### **I68 Training Facility, AL-24-9**

Please accept the following comments from El Paso County Public Health for the project referenced above:

I68 Training Facility, Phase 1 Macro View

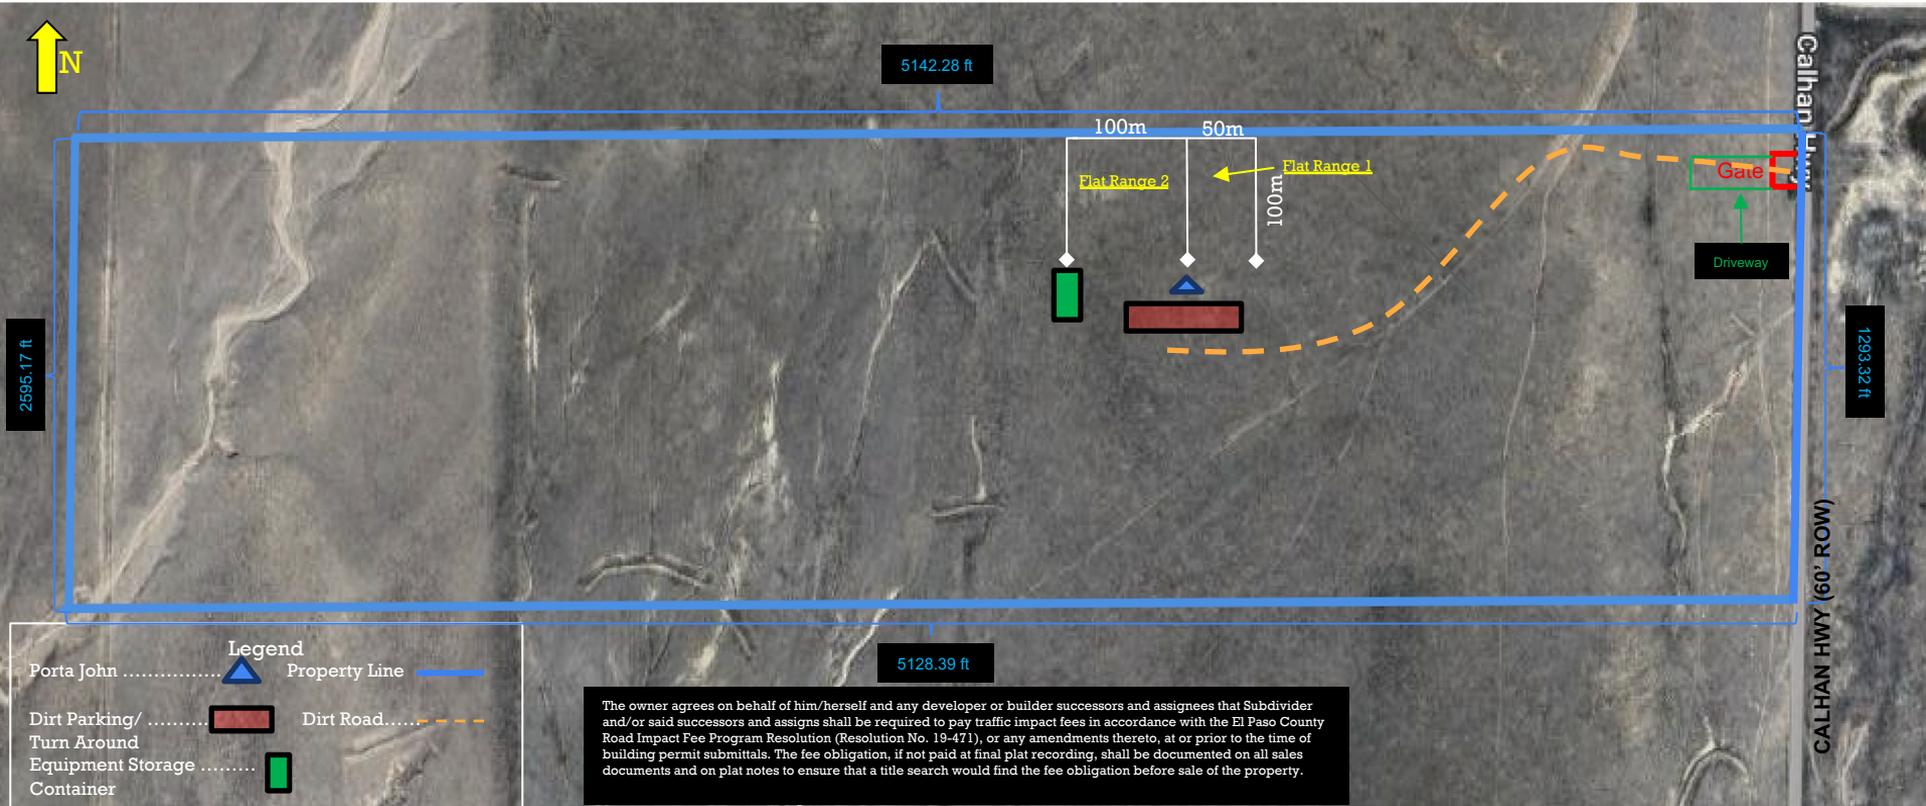
- **No water or wastewater plans were included with the submittal, except for the increasing number of portable toilets through each of the 4 phases. The development plan for Phase 1 plans for the use of a portable toilet, which appears to be acceptable because a permanently occupied building was not identified. The allowed use of portables within Chapter 8 of the El Paso County Board of Health Regulations state:**

I68 Training Facility, Phase 4 Macro View

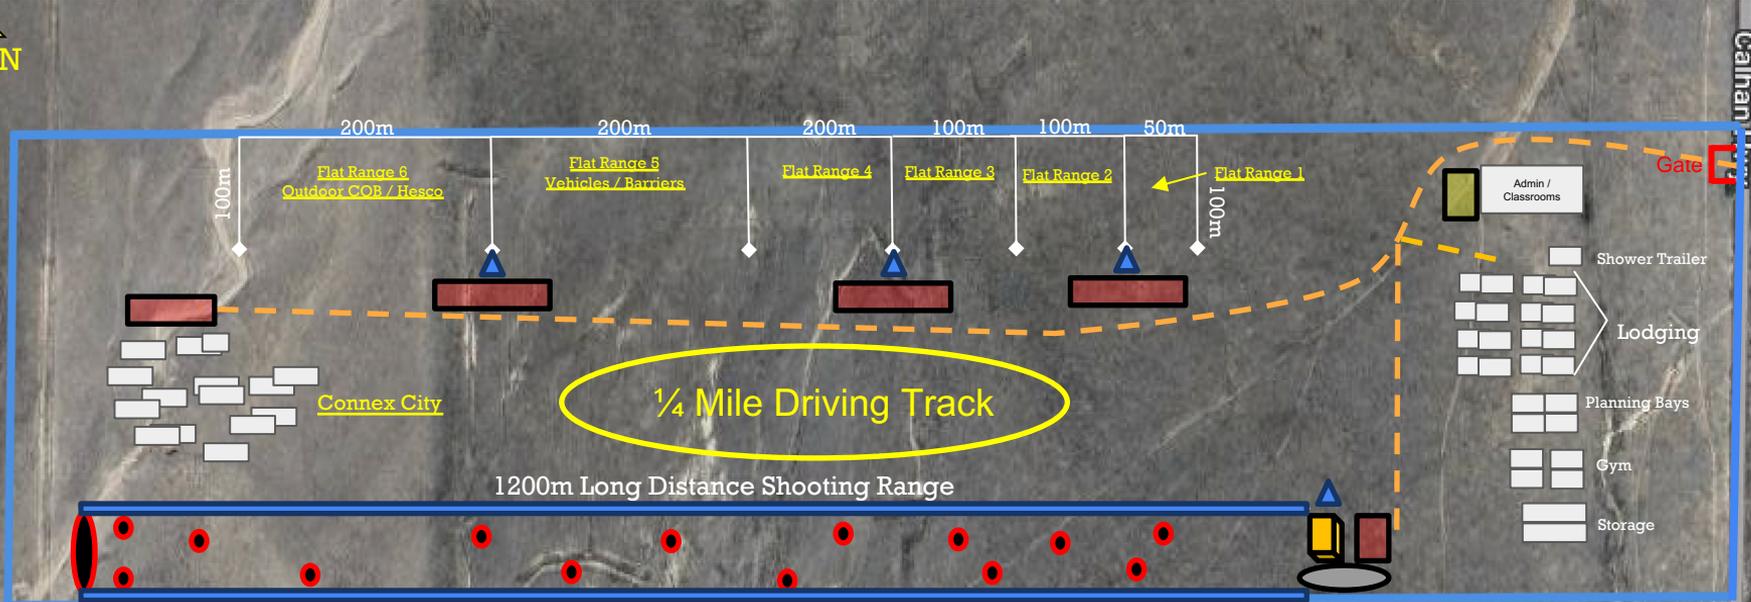
- **The Phase 4 site plan shows an Admin/Classroom, lodging, and showers. This phase of development, if not in an earlier phase, will require the installation of a professional engineer designed onsite wastewater treatment system (OWTS) and full compliance with the El Paso County Public Health, Onsite Wastewater Treatment System Regulations.**
